CITY OF ALBUQUERQUE

August 3, 2012

Re: Bruckner Truck Sales, Inc., Drainage Report and Grading Plan
Engineer's Stamp dated: 7/19/12 (J09/D021)

C2.2

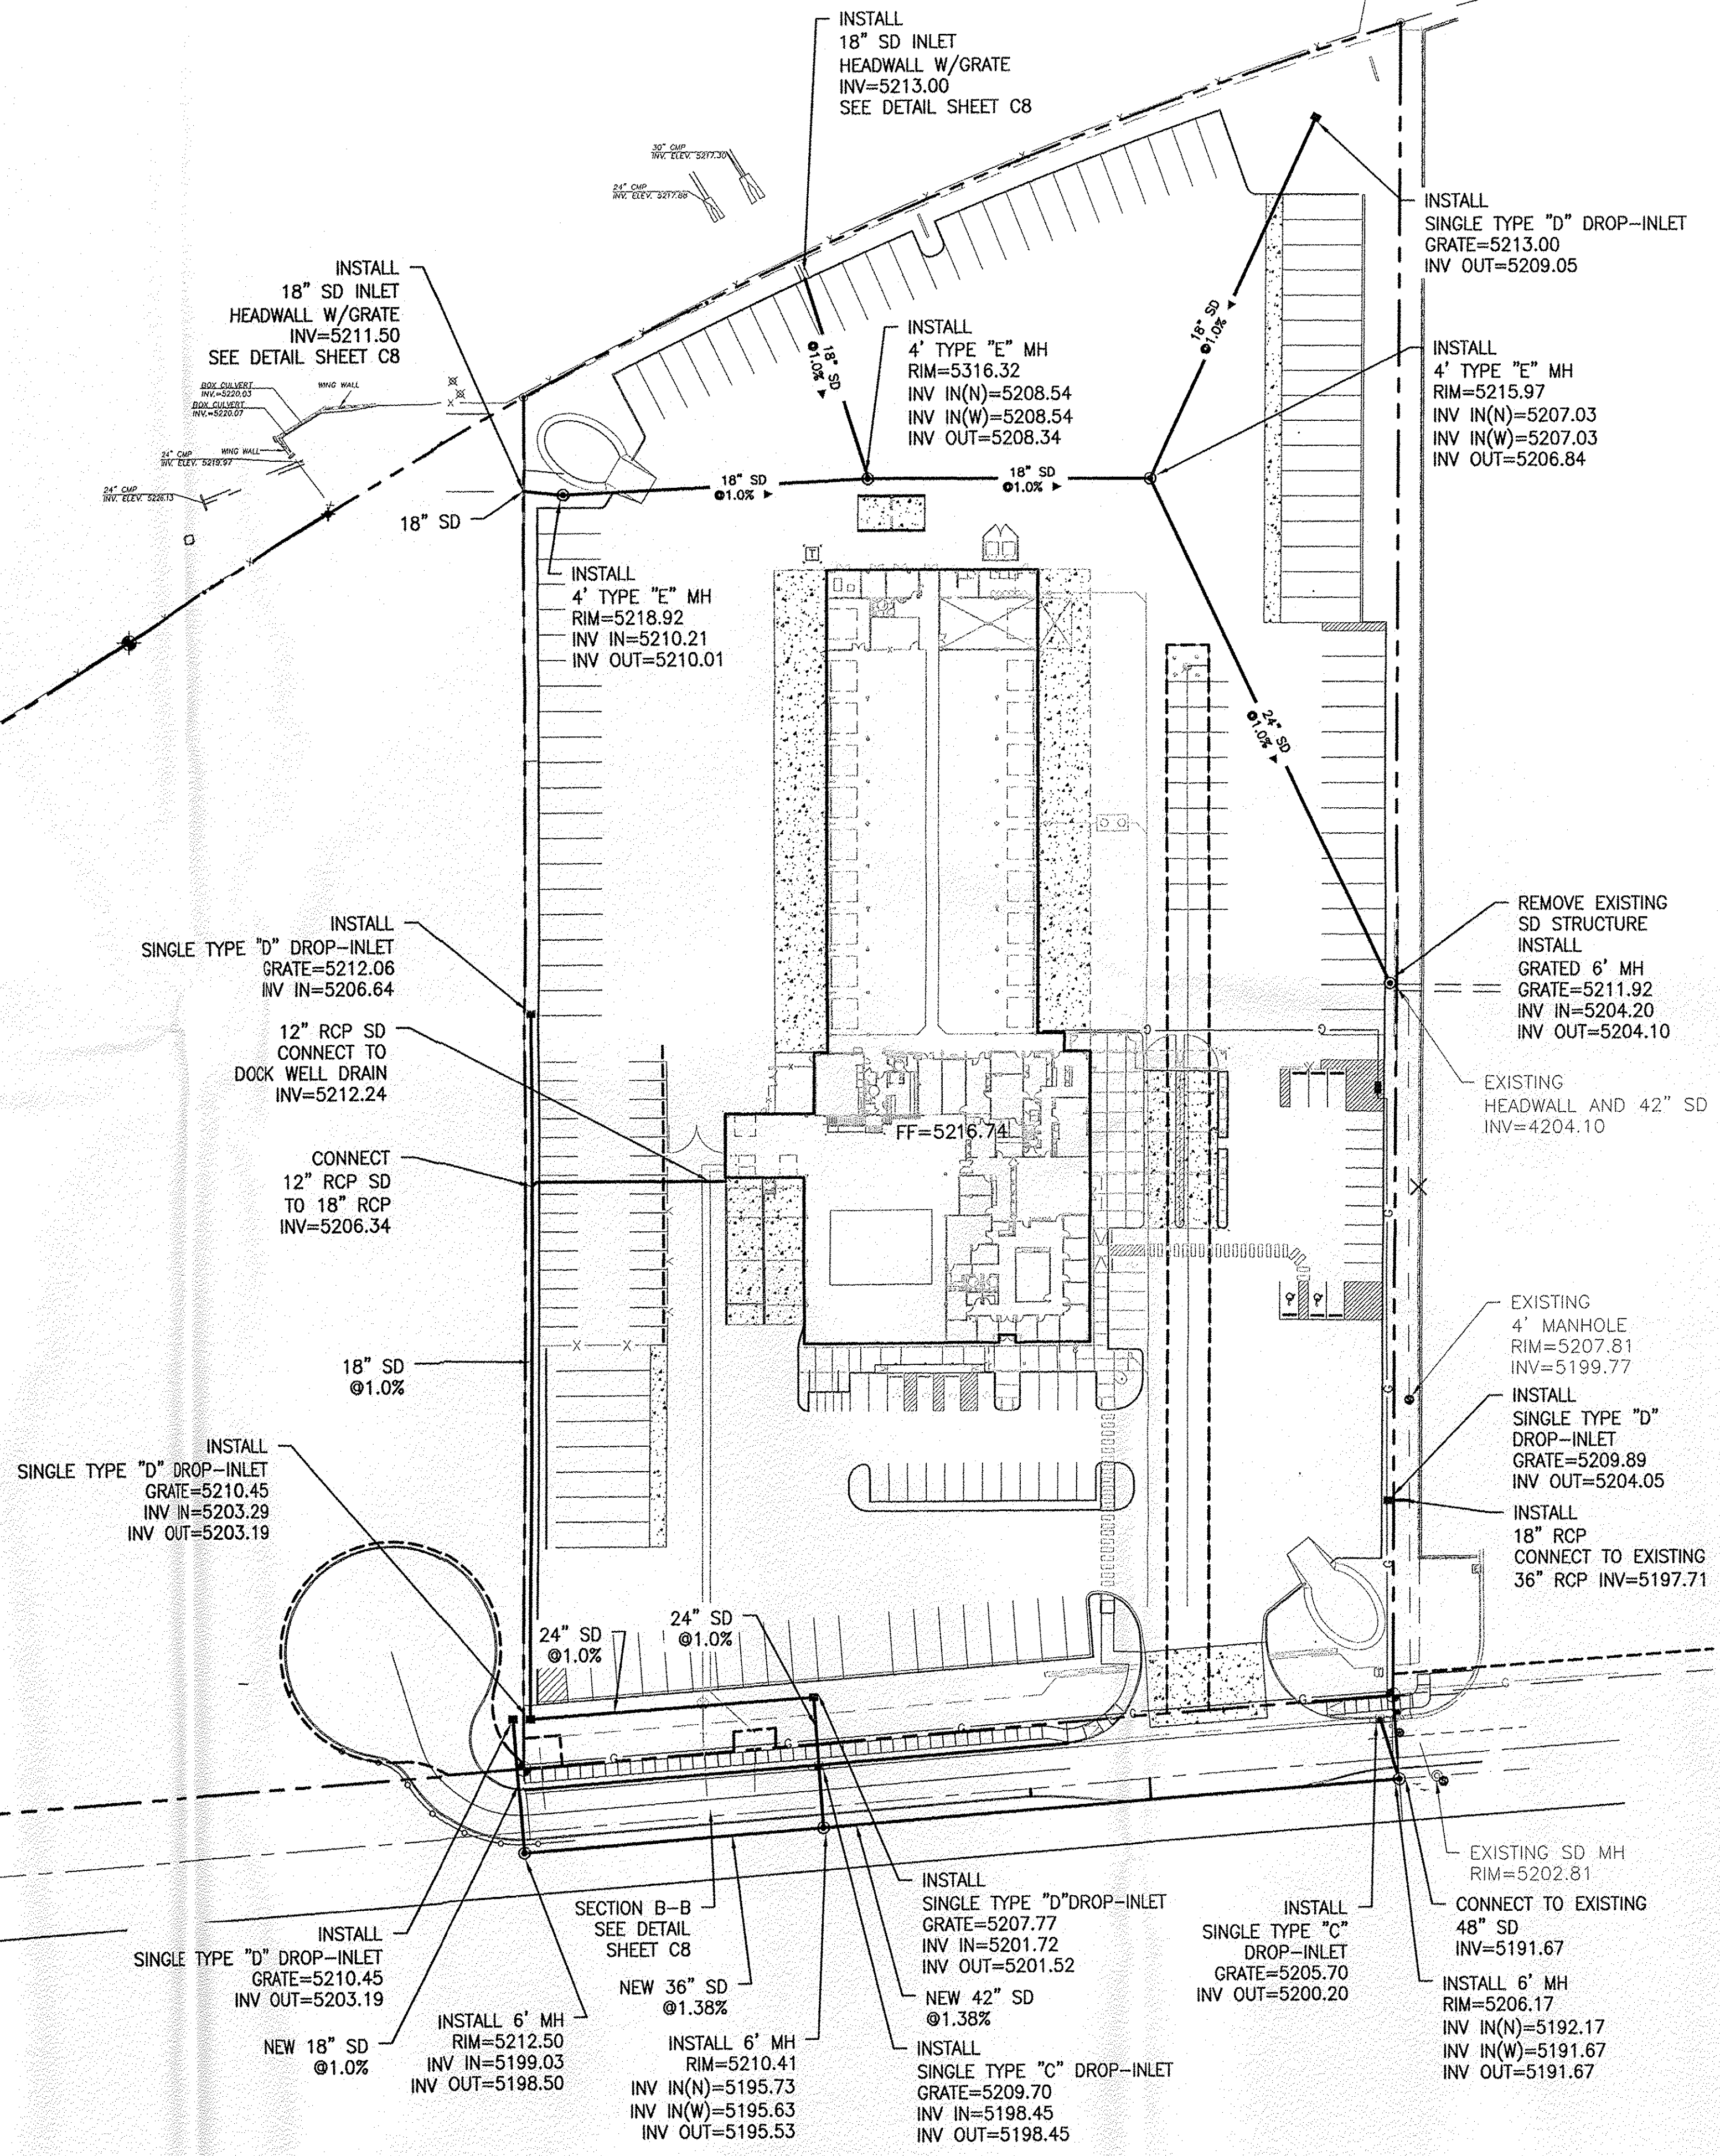
- Include inlet capacity calculations.
- Provide street flow capacity analysis and inlet capacity analysis for Daytona Rd.
- Please provide erosion and scour analysis passed the enclosed riprap for the channel. Would scour wall be required at the end of the riprap?
- What is the status of plugging the 48" storm drain pipe on the north side of the I-40?
